Department of Transportation

June 20, 2018

RE: P181/PUD183/SP181 - Rollin Ridge Estates Residential & Commercial

The CDOT Region 2 Traffic Unit has reviewed the Rollin Ridge Updated Traffic Impact Study from LSC, Transportation Consultants, Inc. dated May 14, 2018 and requests the following;

PRELIMINARY PLAN
ROLLIN RIDGE ESTATES
 EL PASO COUNTY, COLORADO
 T C & C, LLC 17572 COLONIAL PARK DRIVE MONUMENT, CO 80132-2209

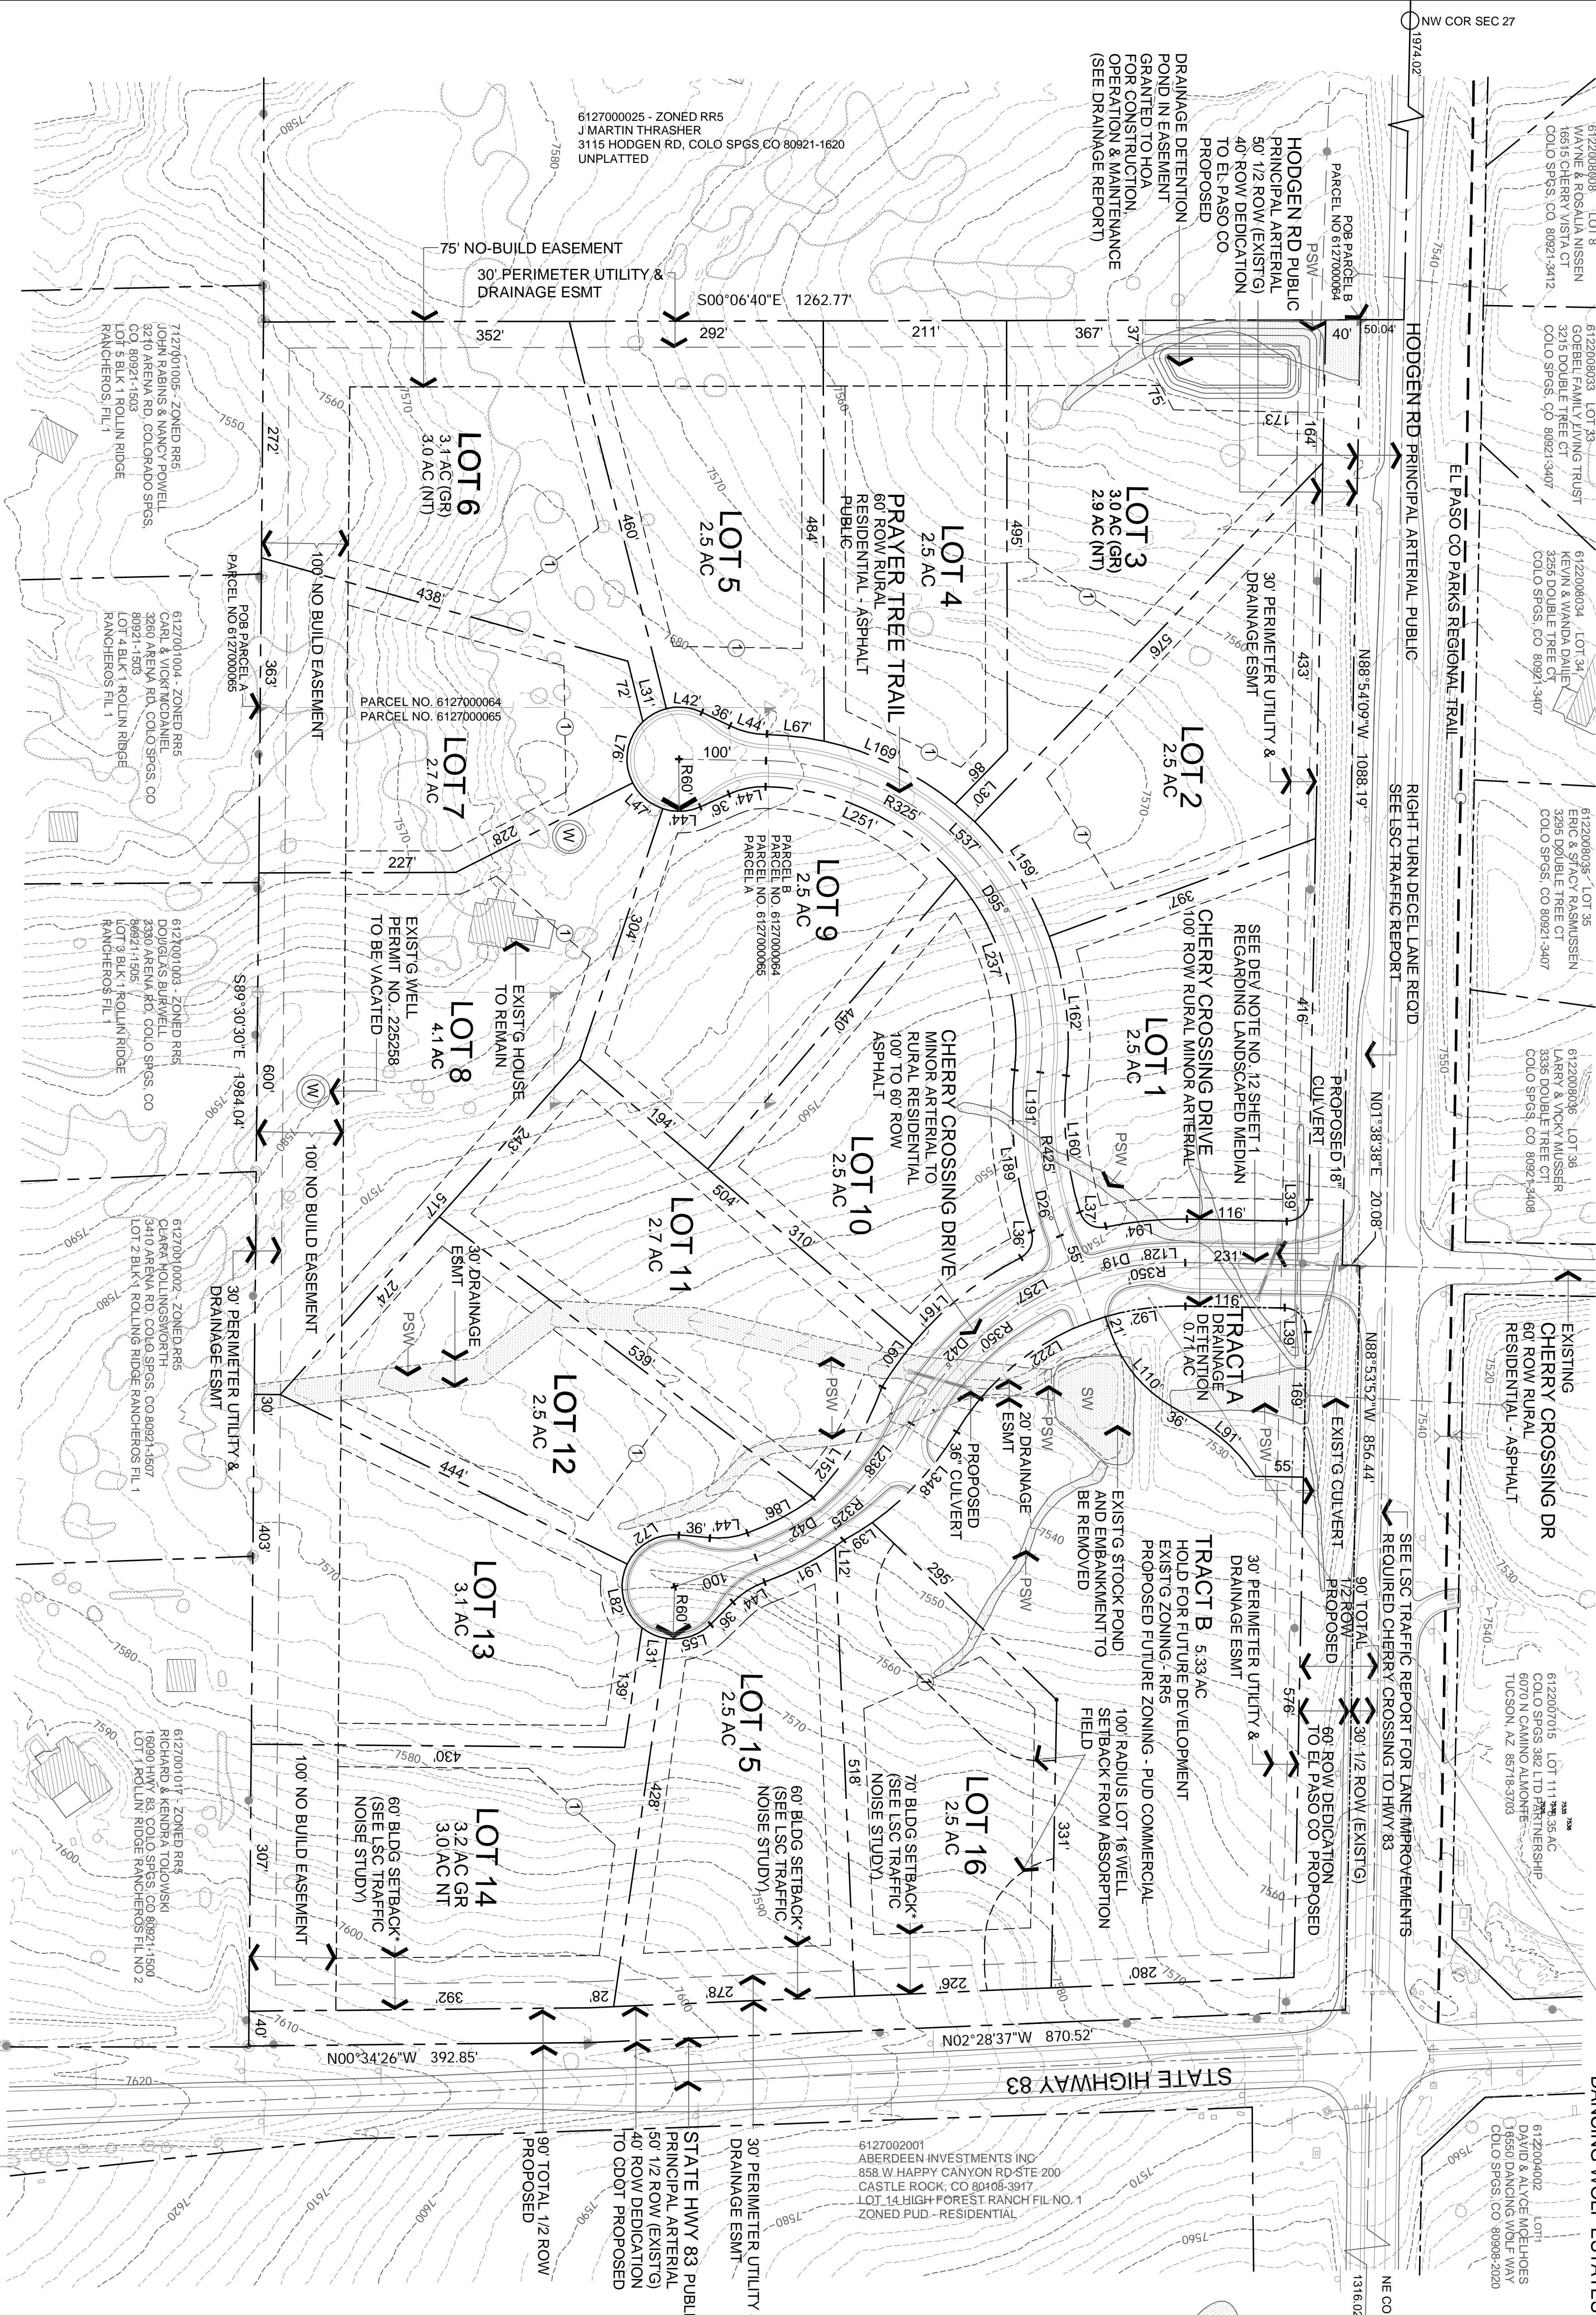
- e) The Department notes a 50 foot distance from centerline of State Highway 83 to the subject property. We request the developer depict this distance on the upcoming development drawings.
